# CITY OF MERCER ISLAND

### Pre-Application Meeting (PRE22-024)

<b>Site Location:</b>	5652 E Mercer Way	<b>Parcel Number</b>	192409078
<b>Lot Size:</b>	10,800 sf 9,000 sf	<b>Zoning:</b>	R-15 (Single Family)
<b>Brief Project Description:</b>	Dock repair and relocation of boatlift	<b>Documents Provided:</b>	Preliminary plans, project questions, SEPA checklist, applicant information
<b>Applicant Information:</b>			
<b>Name:</b>	Madison Johnson	<b>Email:</b>	permits@seabornpiledriving.com
<b>Phone:</b>			206-236-1700
<b>Second Pre-application Meeting Required:</b>	Not Applicable

**SHEET
A2.0**

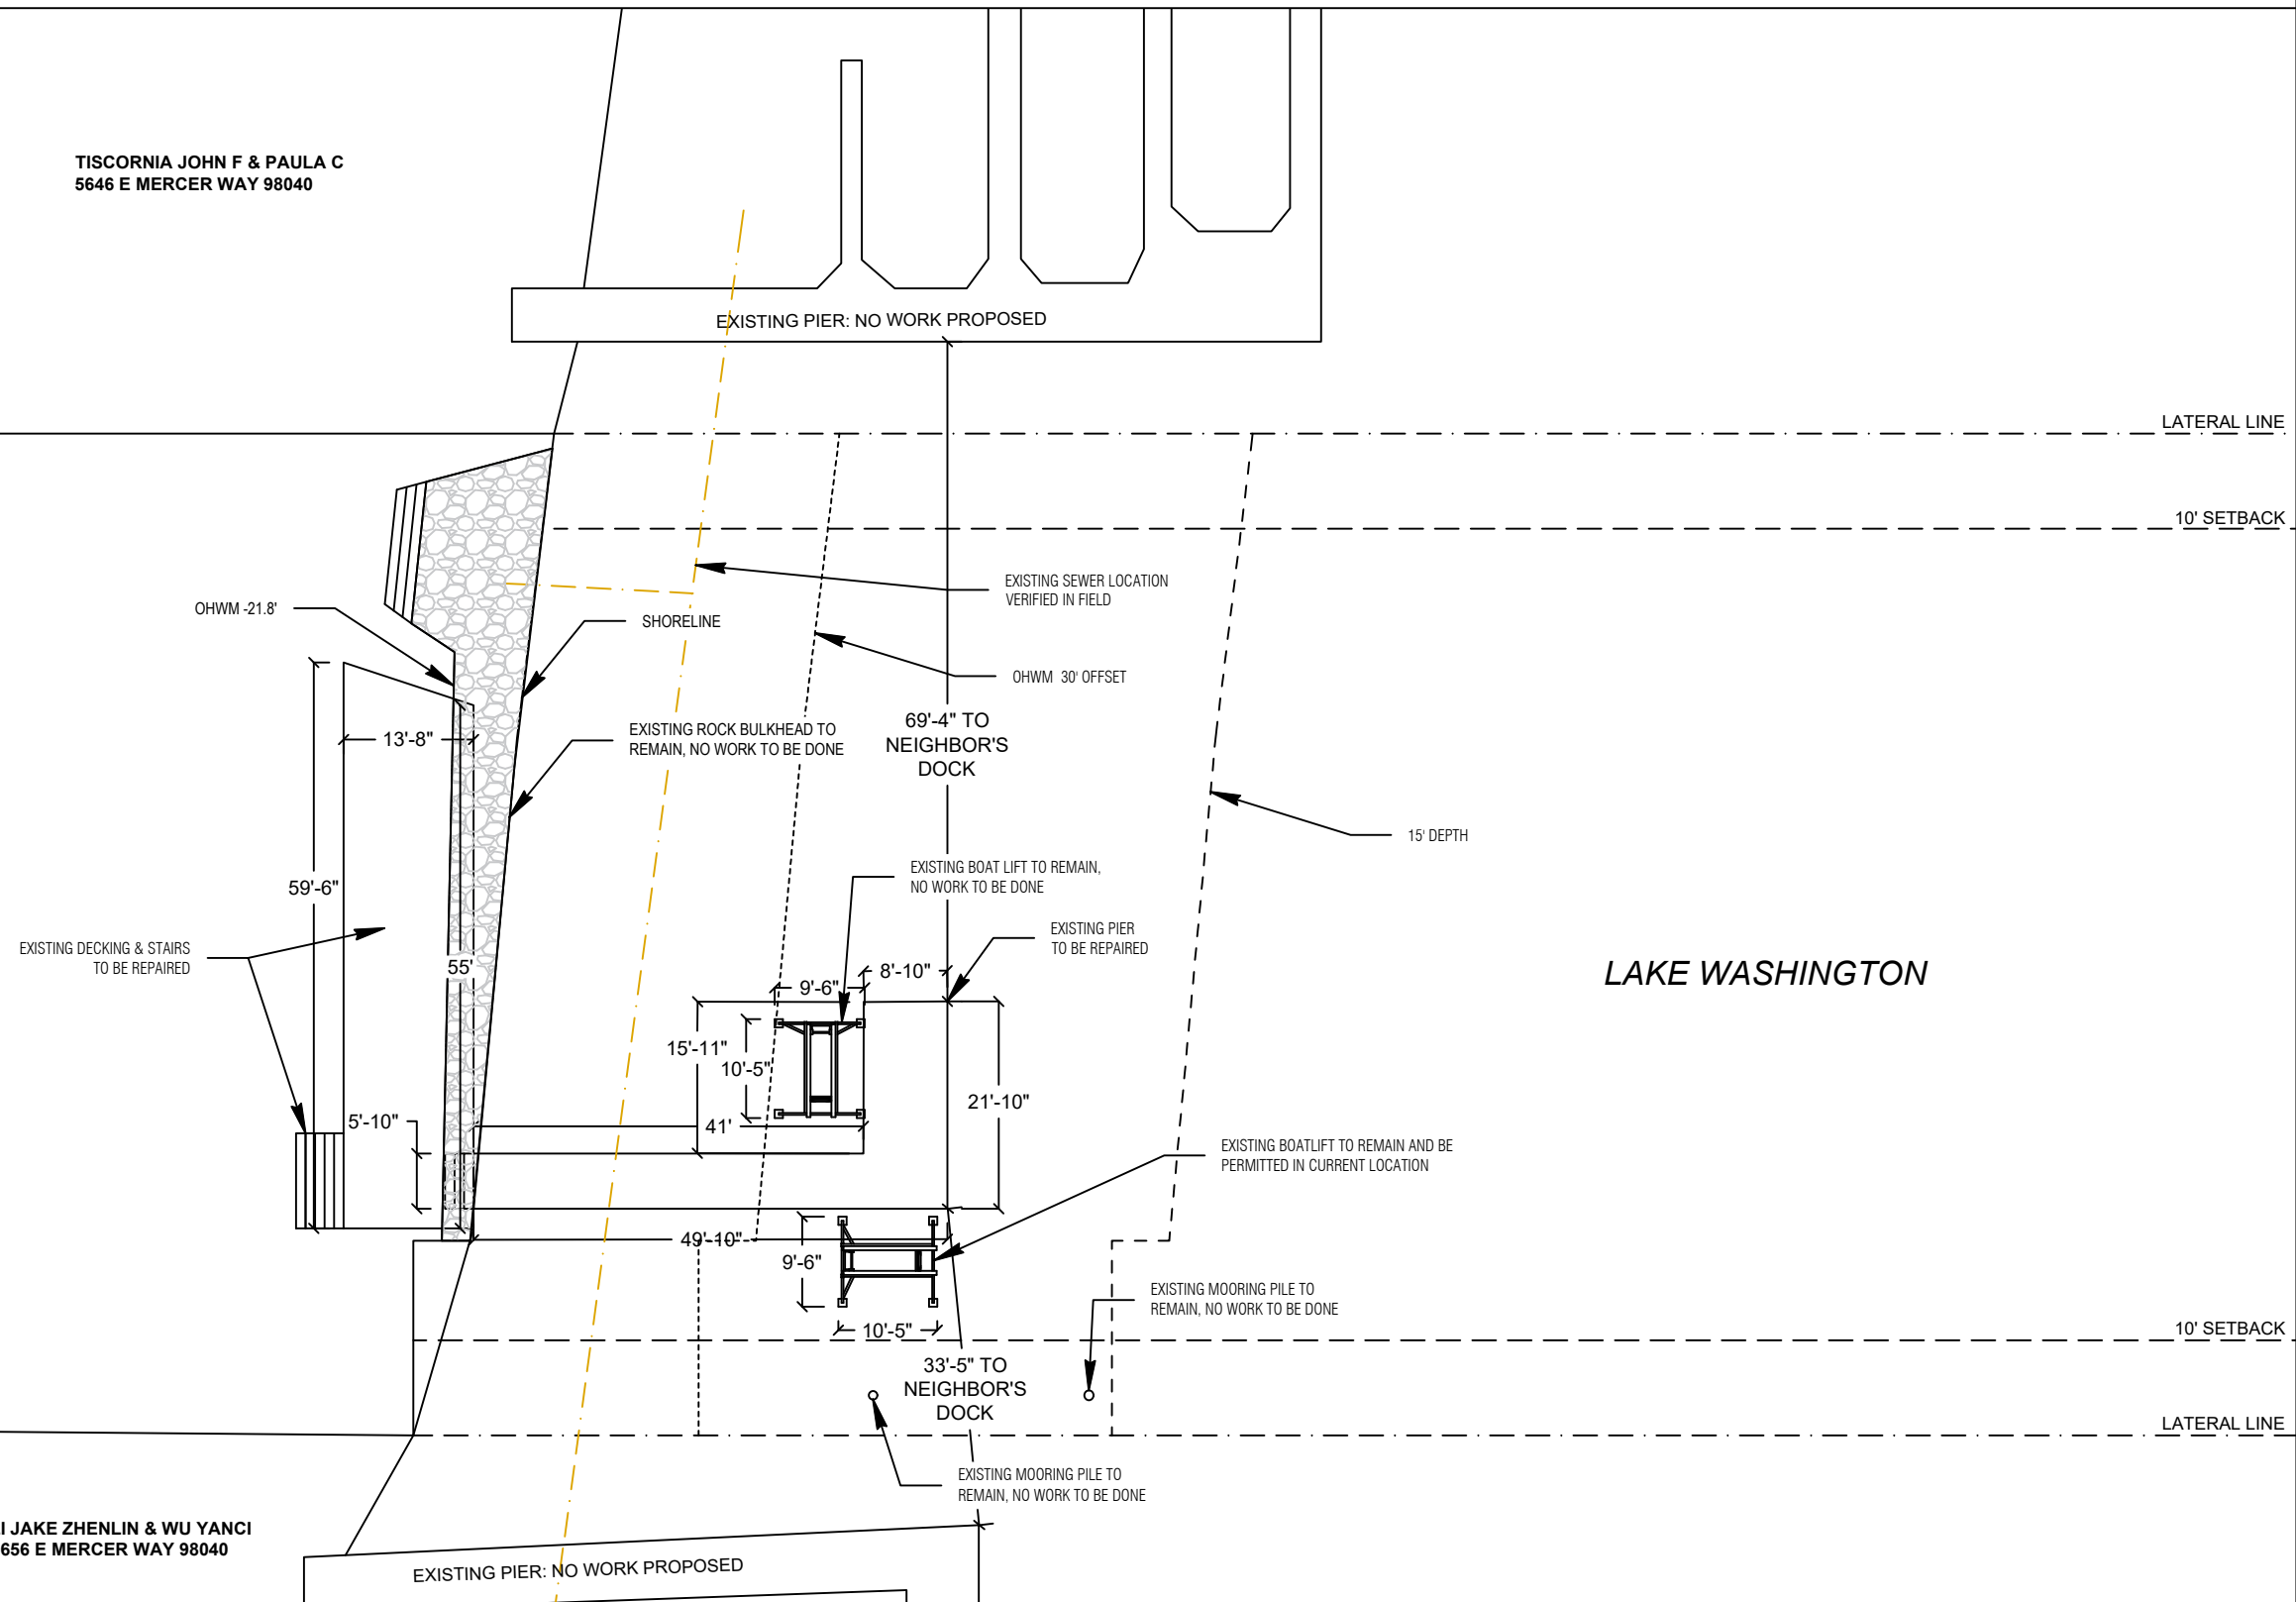
- Label the boatlift that is being permitted in its existing location to clarify that this is a new location for purposes of shoreline permitting. (Sheets A2.0 and A3.0)
- Identify the 0 – 25' and the 25 – 50' shoreline setback areas on Sheet A4.0.
